OUT18/2661

**Cairncross Waste Management Facility Expansion (SSD 5792)
Comment on the Environmental Impact Statement**

Cairncross Waste Management Facility Expansion (SSD 5792) Comment on the Environmental Impact Statement

Figure 1-10 Areas where maximum groundwater levels are above the landfill floor level

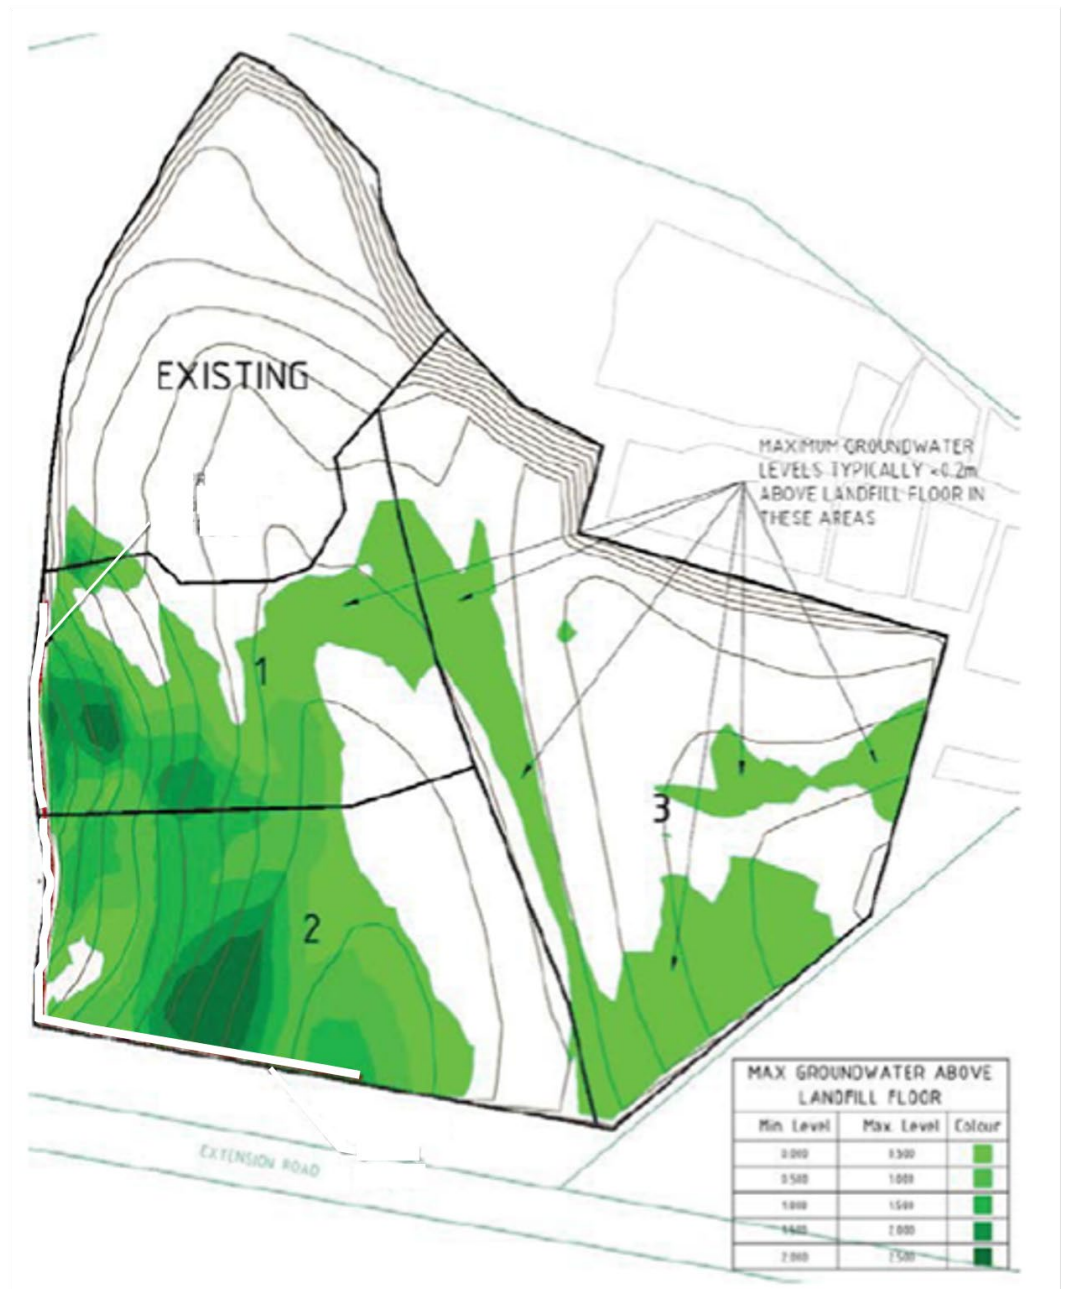
- It is not clear from the EIS if groundwater level triggers are being established to protect the risk of hydrostatic pressure beneath the landfill generating lift and potential perforation of the HDPE liner.

- It is noted on-going management of groundwater beneath the site is based on performance of the gravel trench. The trench is required to keep the site dry during construction and to limit the build-up of hydrostatic pressure beneath the landfill. If the hydrostatic pressure is sufficient, uplift of the HDPE line can occur, leading to perforation from content in the landfill.

- Managing the recovery of groundwater levels post construction will be a key issue in the operation of the facility. As stated in the EIS "In accordance with the draft Solid Waste Landfill Guidelines (NSW EPA, 2016), and to prevent high groundwater heads affecting the performance of the landfill liner, it is proposed to install a drainage trench". To add confidence in the ongoing monitoring and reporting program, further detail is recommended on the water level triggers from monitoring bores in relation to maintaining a buffer beneath the landfill to limit hydrostatic pressure, noting that bores located adjacent to the trench are likely to be lower than that beneath the adjacent parts of the landfill.

Figure 10: Typical Sediment Basin Plan

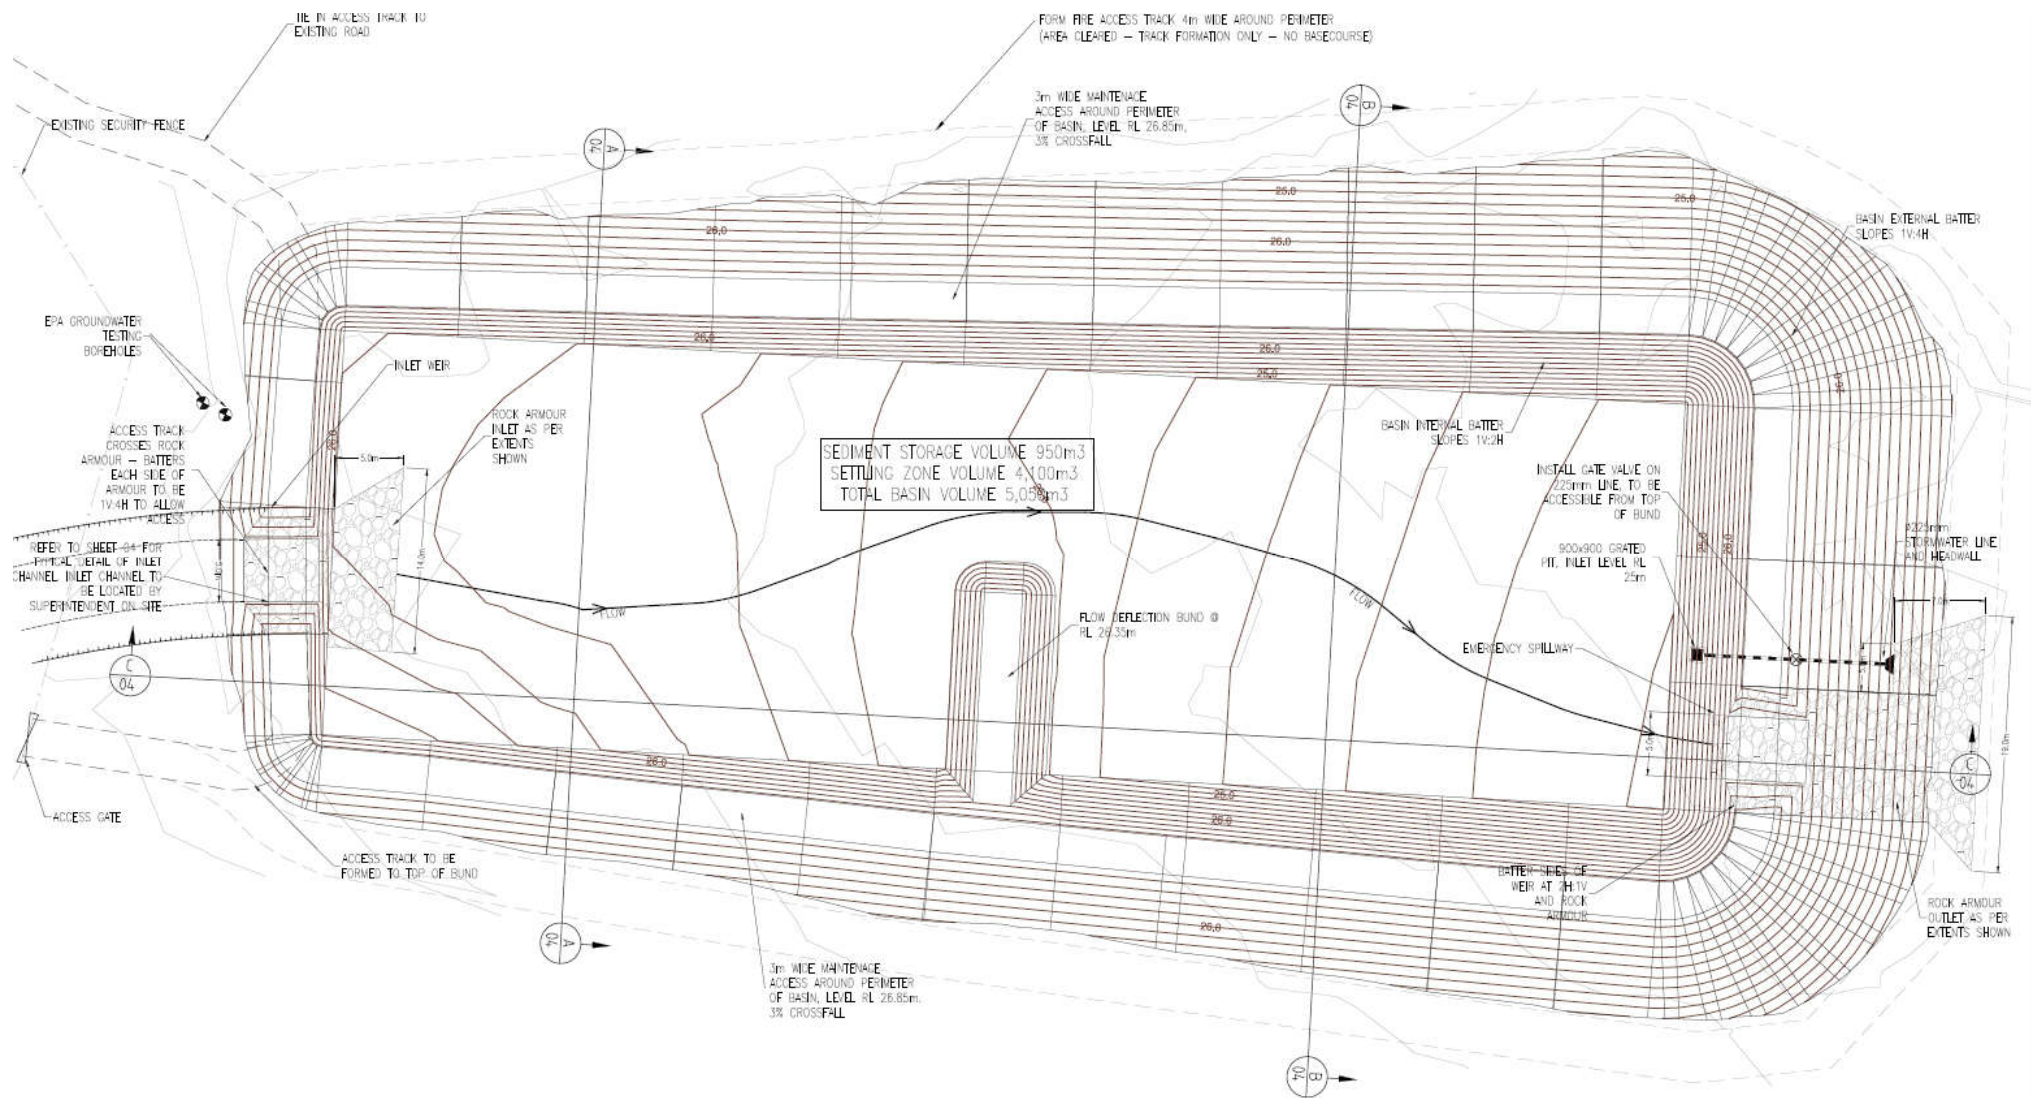
- The proposed sediment basin sizes for stage 2 is predicted to result in an increase in post development velocities by 10% for a 1 in 20yr ARI event and 18% for a 1 in 100yr ARI event. The EIS has deemed this increase not to be an issue due to the infrequent nature of such events. The impacts of such an increase on erosion and resultant sedimentation and aquatic habitat impacts have not been addressed. Where impacts are predicted, mitigating measures would need to be developed.
